Adam Brookes

Interested Party ref no. 20035951

Examiner's First Written Questions ExQ1 - Question Q1.0.19

The Outline Landscape and Ecology Management Plan (APP-210) lacks detail about the permissive path design.

Appendix 2 – Green Infrastructure Strategy Plans

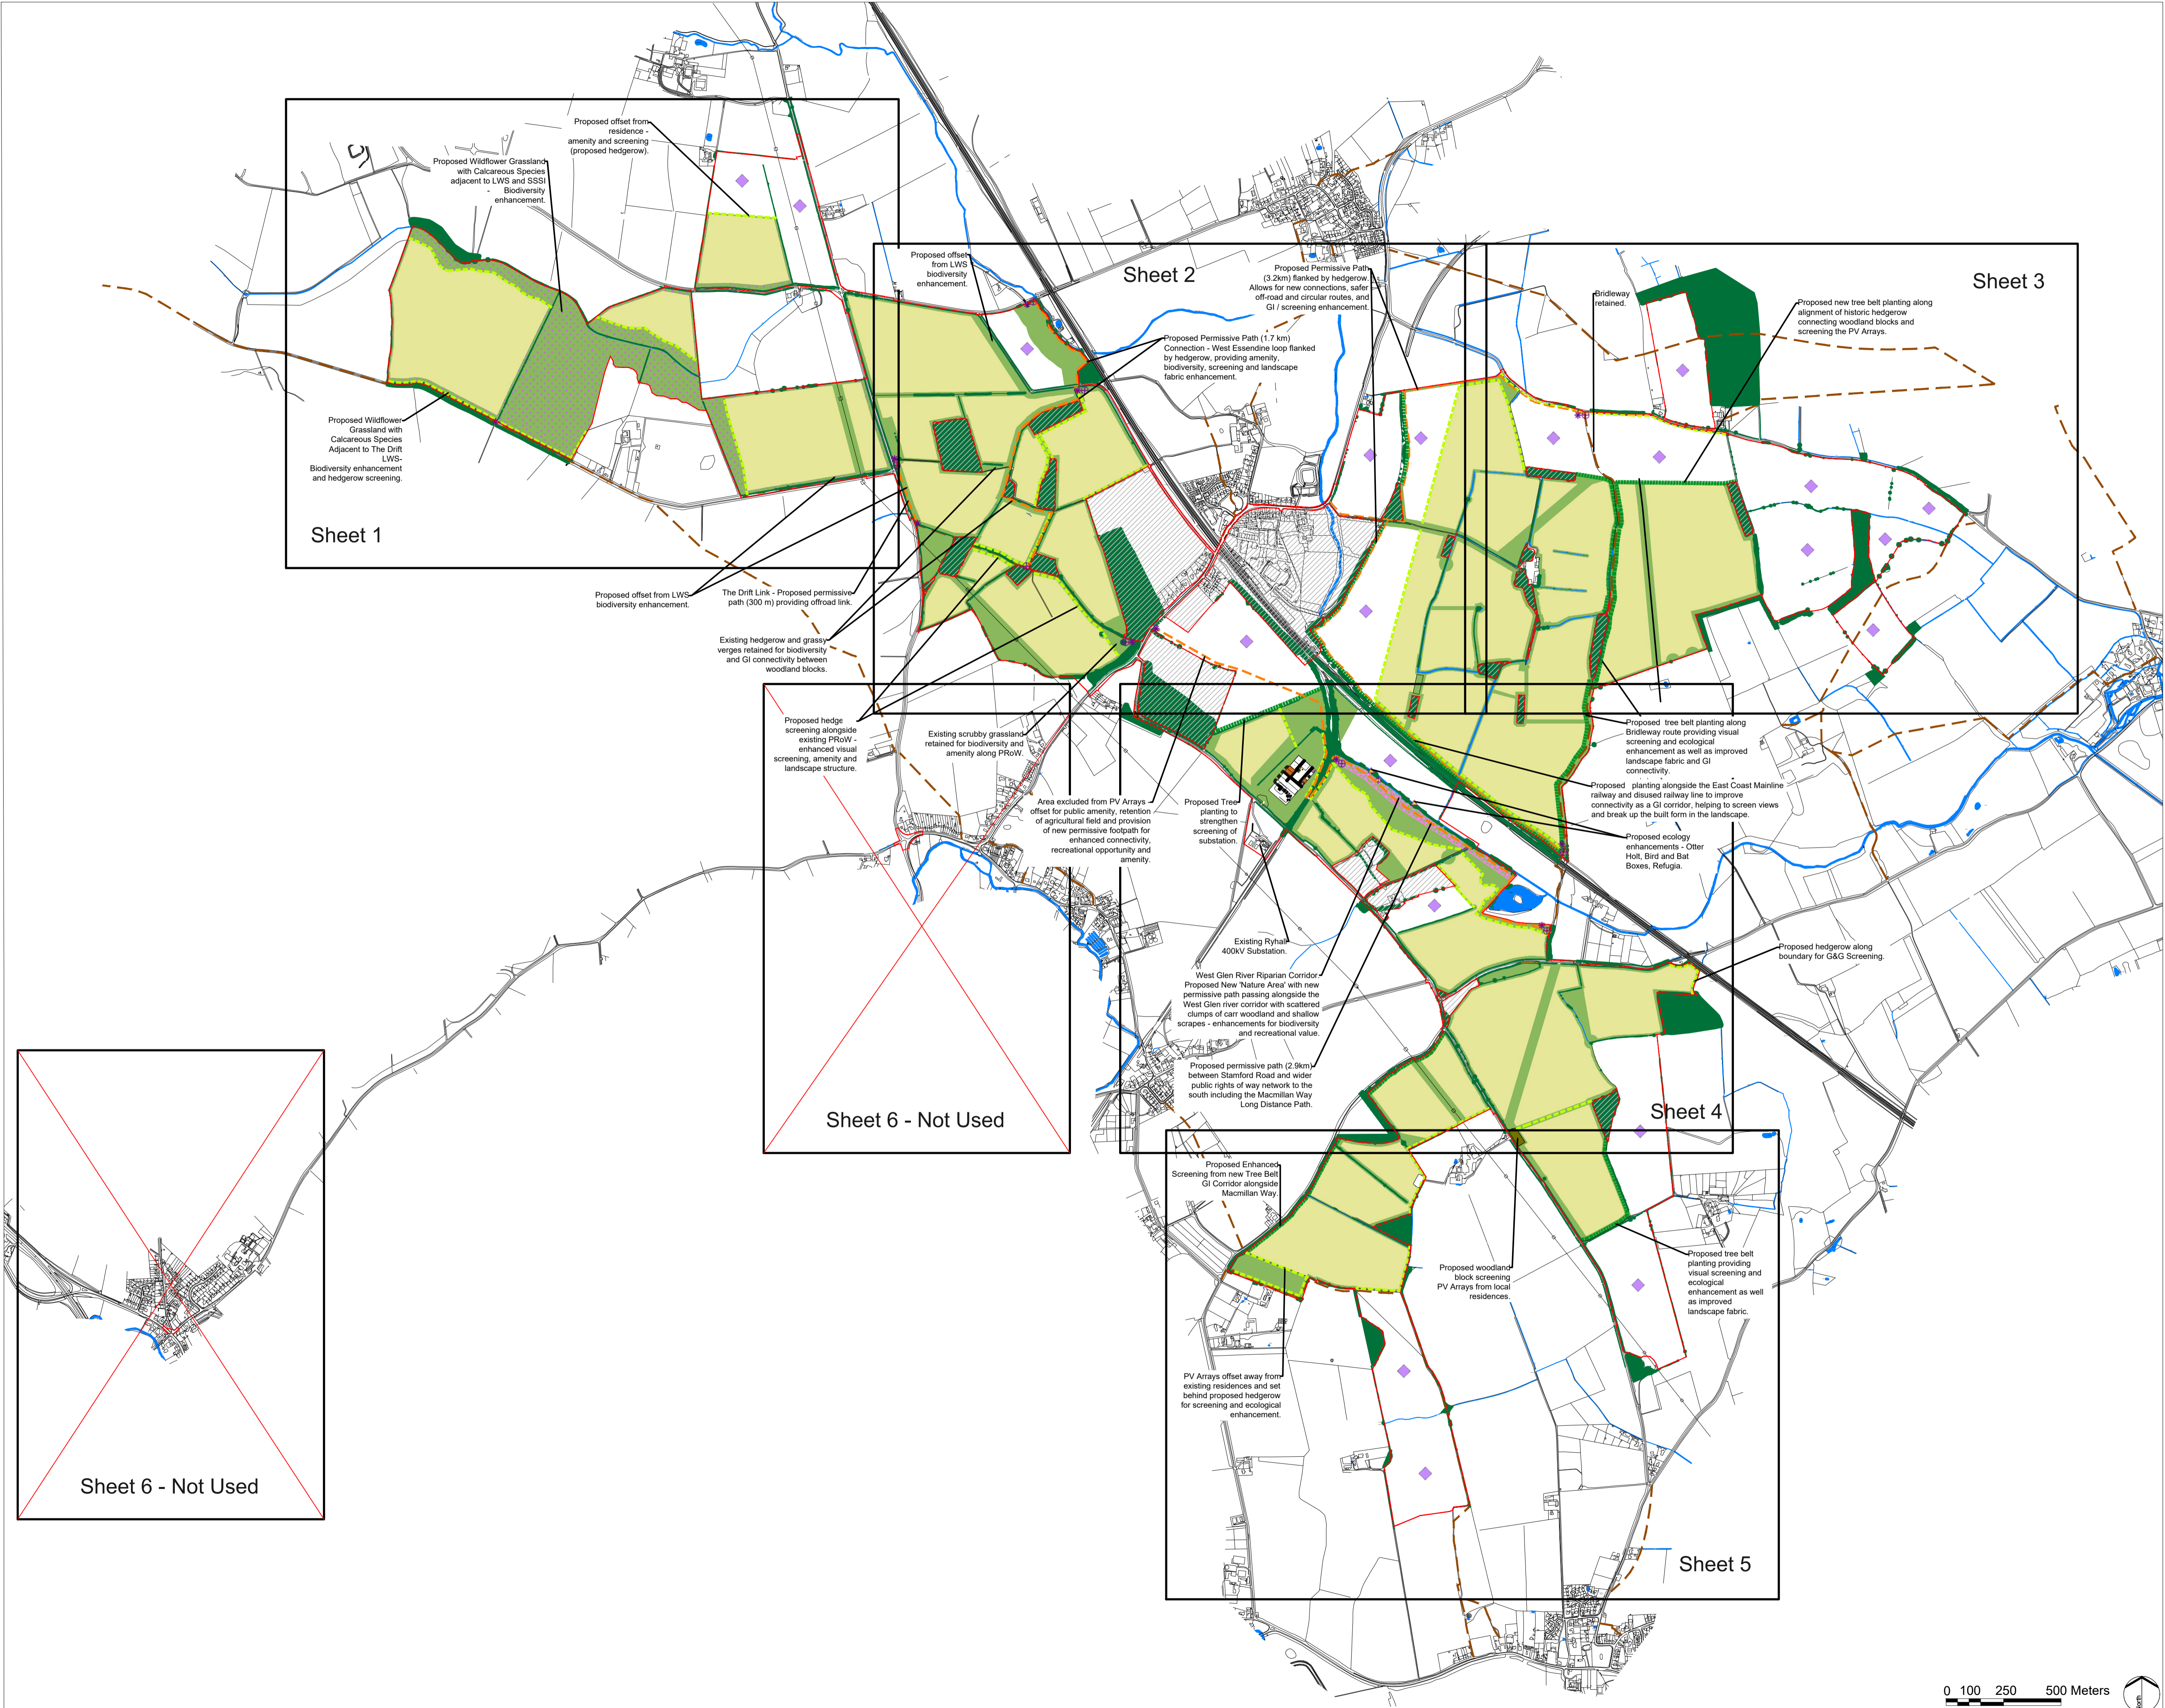
The plan does not provide details of the design of the proposed permissive paths, nor indicate the categories of user which will be permitted which would guide their design. These matters are left to be approved by the relevant planning authority via requirement 7(h) of the draft DCO.

I would like to see greater detail in the Outline Landscape and Ecology Management Plan to better guide the local planning authorities on what they should consider to be acceptable. This would also help to reduce the risk of inconsistencies in the approach of the planning authorities.

It would be helpful if the plan included items such as:

Surface treatments

Widths

Design of gates/stiles

Waymarking

The preference would always be for the proposed permissive paths to be open to the most categories of users, including cyclists and equestrians. There are no technical challenges apparent that would prevent this.

The route between the primary construction compound and the A6121 is particularly constrained and likely to see significant construction traffic. Therefore, there would be a significant benefit for the proposed permissive paths on both sides of the East Coast Mainline are suitable for cyclists. This would enable more users to avoid potential conflicts with construction vehicles.

It would be helpful therefore for these routes to be surfaced with MOT Type 1 or similar, to provide a surface that will be suitable for a wide range of bikes and in all weathers.
